**Planning Application Reference No.:** 3/2024/0613

**Address of Development:** Inglemead  
Waddington Road  
Clitheroe

**Planning Application No:** 3/2024/0613  
**Grid Ref:** 374223 442303  
**Proposal:** Demolition of existing single garage and construction of new single-storey two bedroom dwelling.  
**Location:** Inglemead, Waddington Road, Clitheroe BB7 2HN

5 Street Elevation
Scale: 1:100

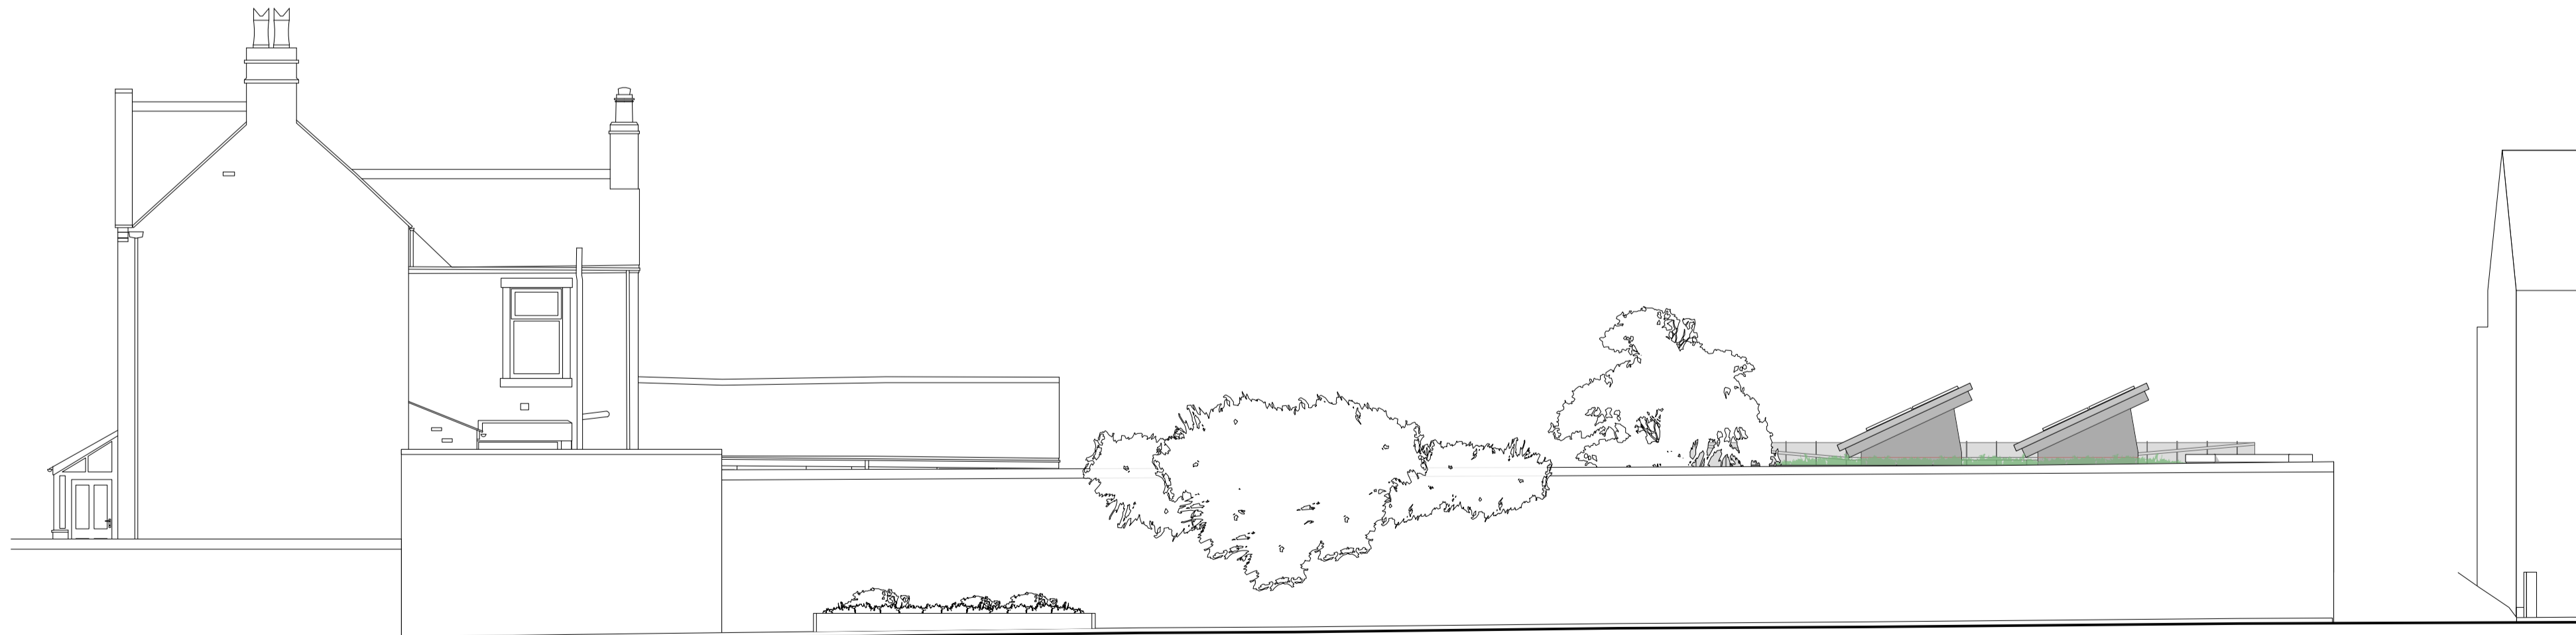
The design and construction of the proposed building are incongruous and completely out of character amongst the Victorian properties in the immediate area – the designers have called it a “simple zinc box”. There also appears to be an error in the measurements for the garden wall along Hawthorne Place (using the wording “the dwelling is *similar* to the existing boundary walls”) and what would be visible from street level – not to mention what would be visible   
 and the new residents.

The measurements stated on the proposal are in our opinion incorrect meaning that the “zinc box” would be more visible than suggested on the plans ,again totally unacceptable .

4. There seems to be a discrepancy with the height measurements of the wall as the height of this decreases as it progresses down Hawthorne Place, and the height at the rear end of the Inglemead garden is only 2.80 metres, which would mean the height of the proposed dwelling would be truly visible from the street, from the plans it would stand over half a metre higher than you have anticipated making the simple zinc box very much seen.

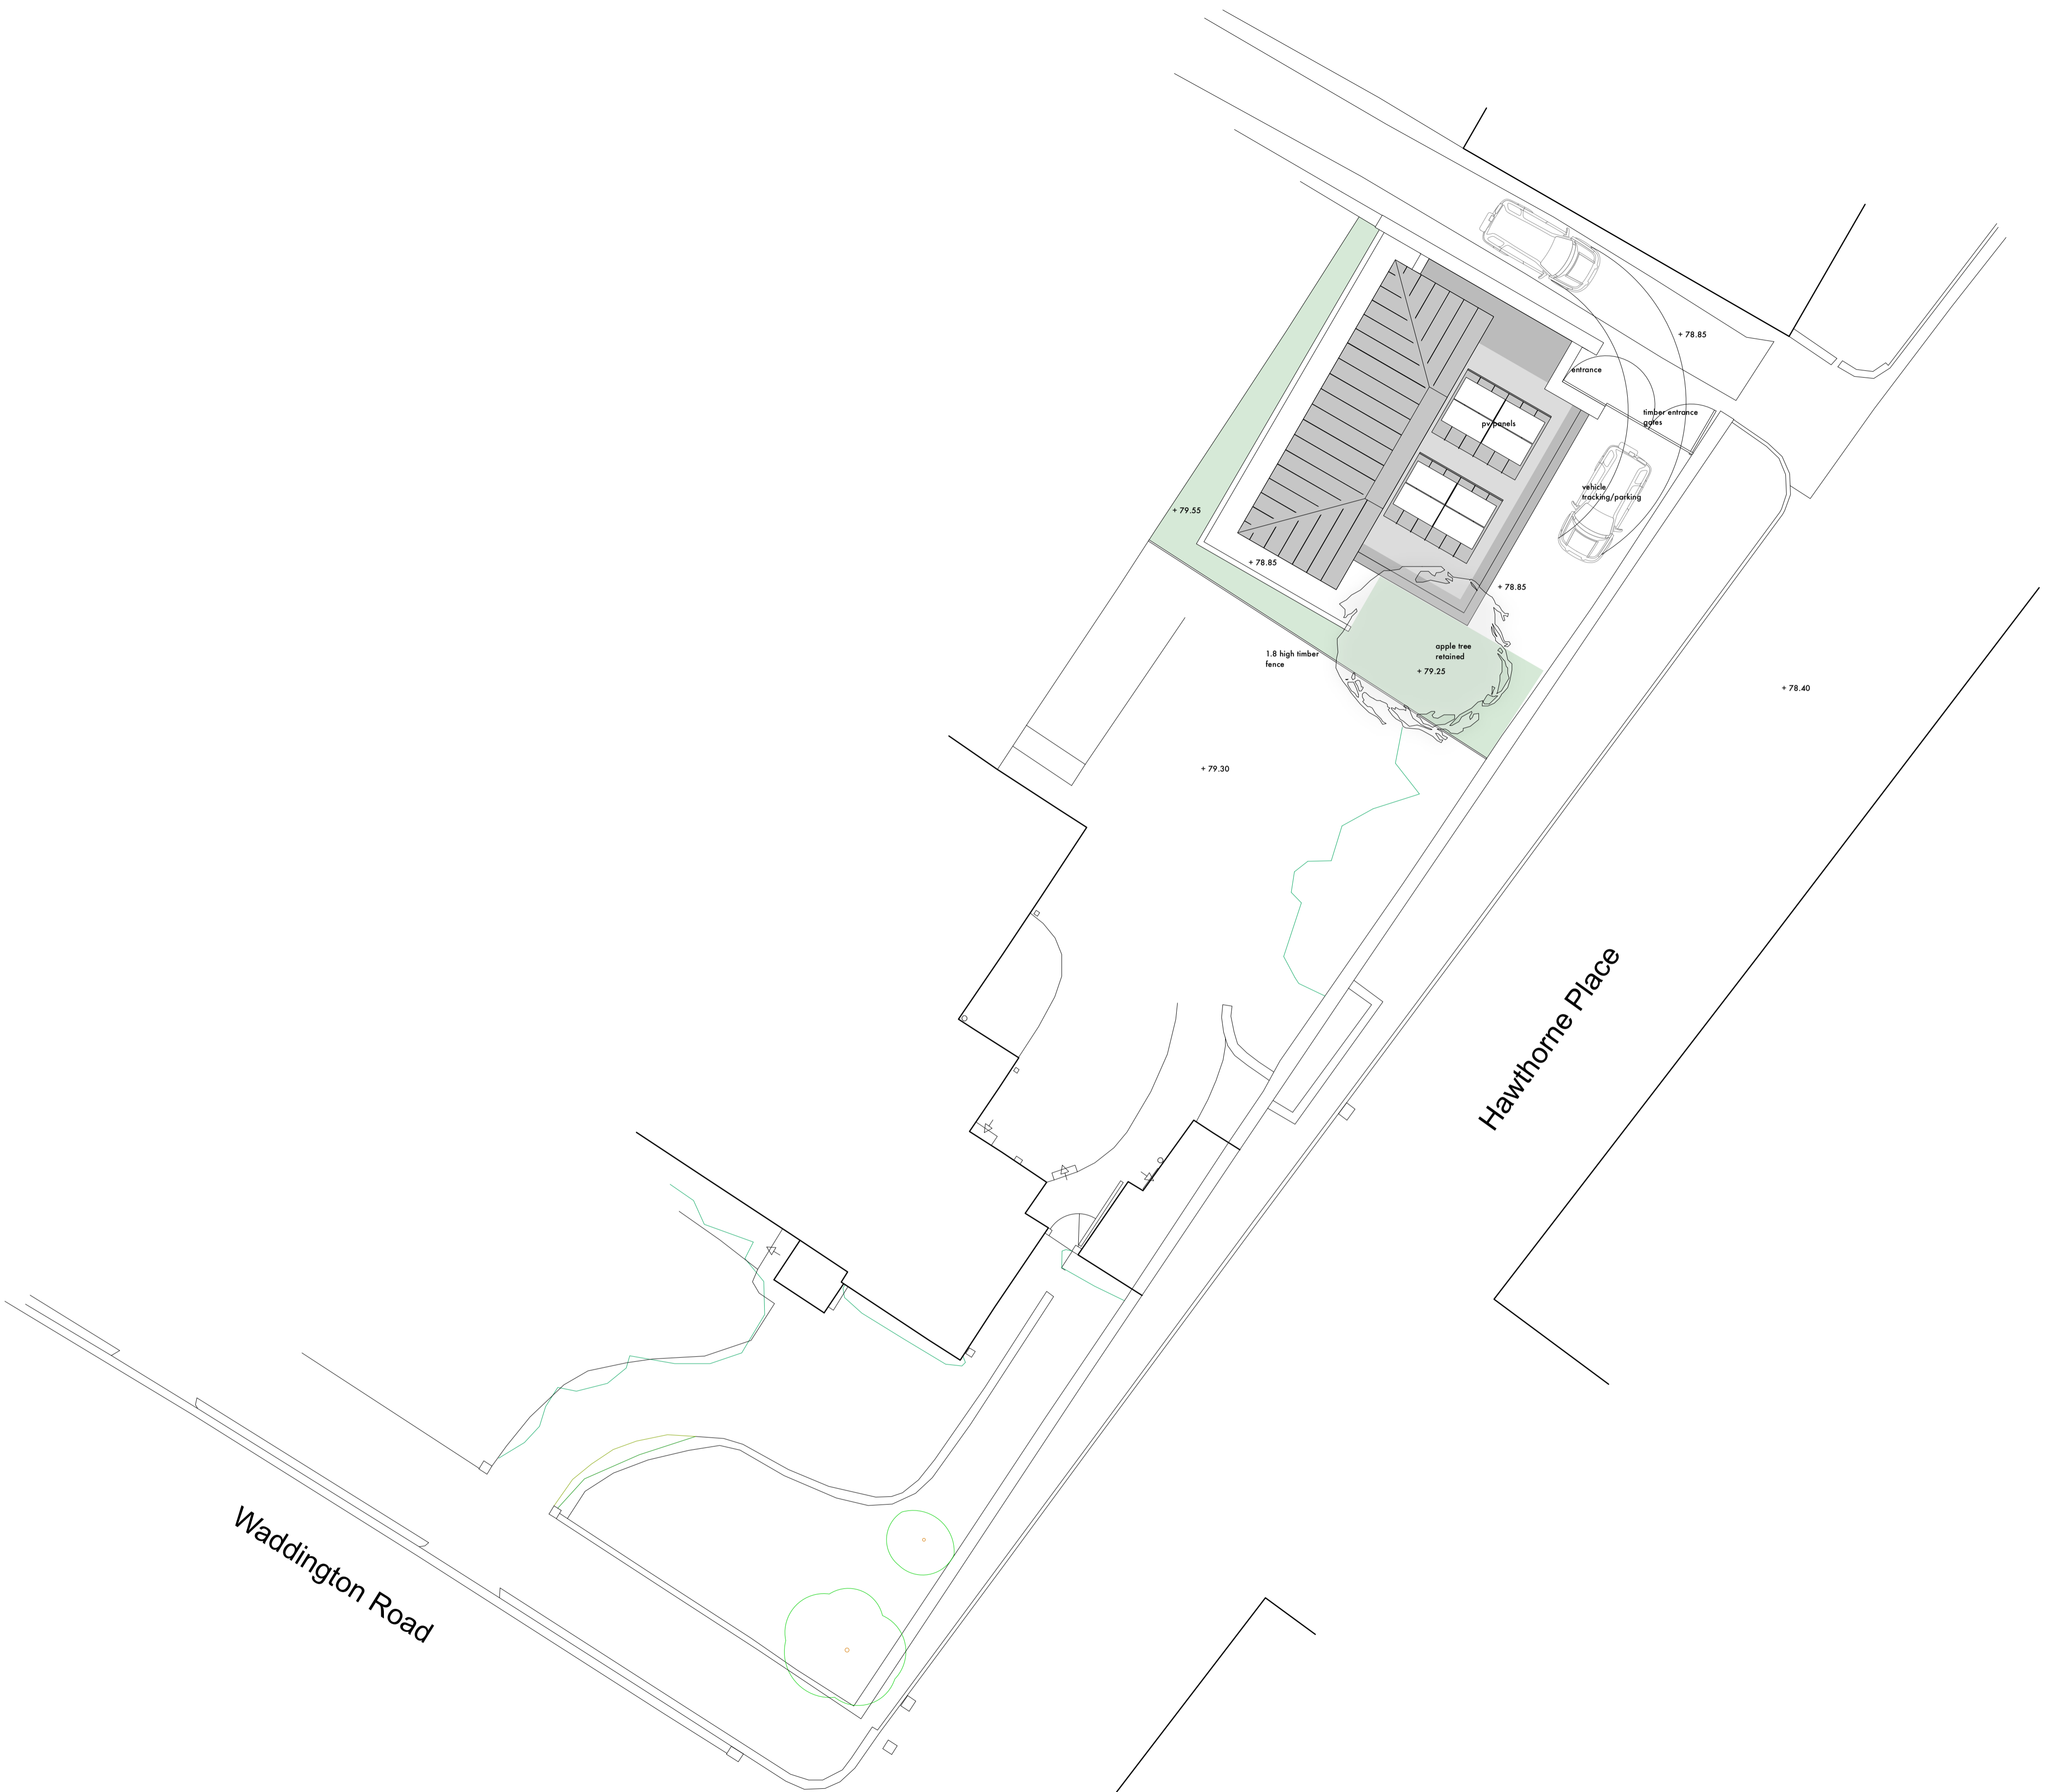
The design clearly shows that a vehicle would be utilising a parking space on the new site, with this I would challenge anyone to be able to reverse into the opening due to the width of the access road. I would object as the calculations have clearly not been checked. Bearing this in mind, the only solution would be to utilise parking on Hawthorne Place.

The access to the proposed parking place in our opinion would require some manoeuvring which is probably why in the ([REDACTED]) we have not witnessed the existing garage being used !! This in itself would be a danger to other road users and pedestrians .
